Sent: 11 November 2013 21:43
To: Planning
Subject: Welwyn Hatfield Council Online Planning - Comment

Application Number: N6/2013/1938/MA
Name: Welwyn Garden City Society
Address: c/o 125 Daniells
Welwyn Garden City AL7 1QT
Comment Type: Object
Comment: APPLICATION REFERENCE N6/2013/1938/MA PROPOSED COUNCIL OFFICE EXTENSION (AMENDED PLANS) AN OBJECTION ON BEHALF OF THE WELWYN GARDEN CITY SOCIETY

Title Proposed Materials

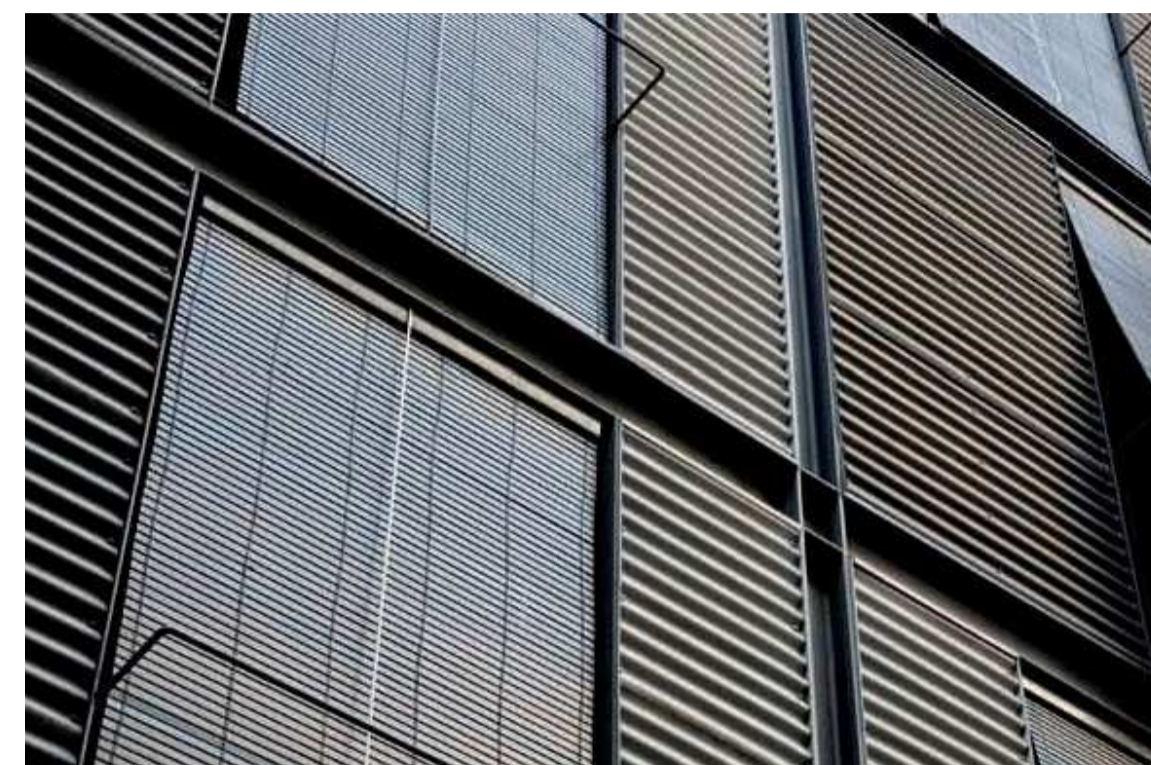
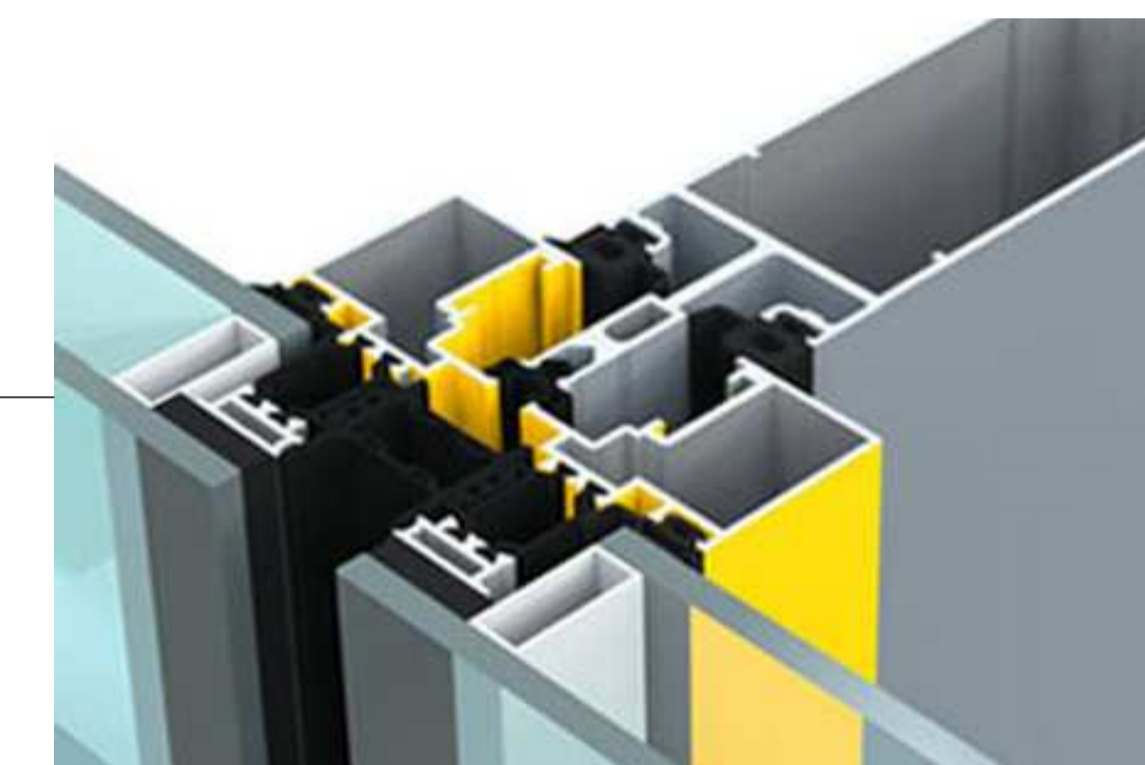
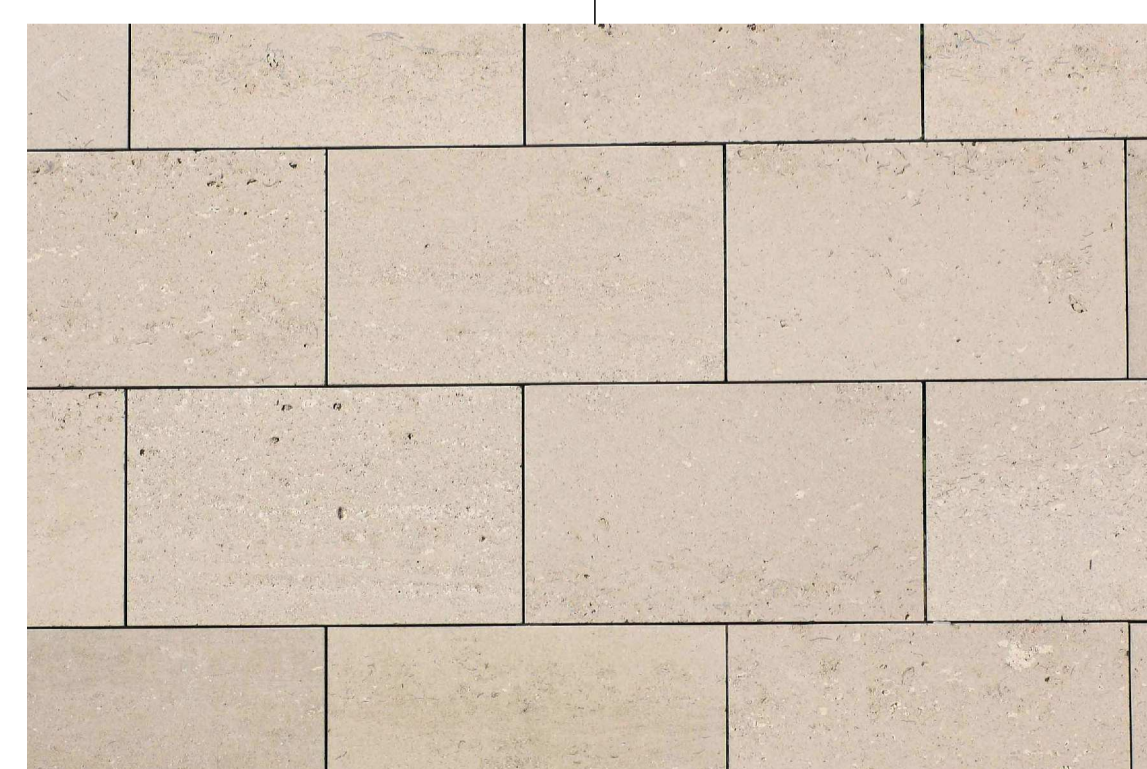
The revision to make the glass facade vertical and to alter the plan profile of the frame; to create the illusion that it is slimmer is unsuccessful, while the new portico is both larger and a more dominant element than the original scheme, copying the detail of the main entrance is without merit.

The proposed glazed facade to the rear, faces approximately south east and will be exposed to the low sun penetration for a six month period from Autumn through to Spring, the steps being taken to counter this could be difficult to control. Reliance on controlling it with solar control glass, will require more reliance on air conditioning and lighting.
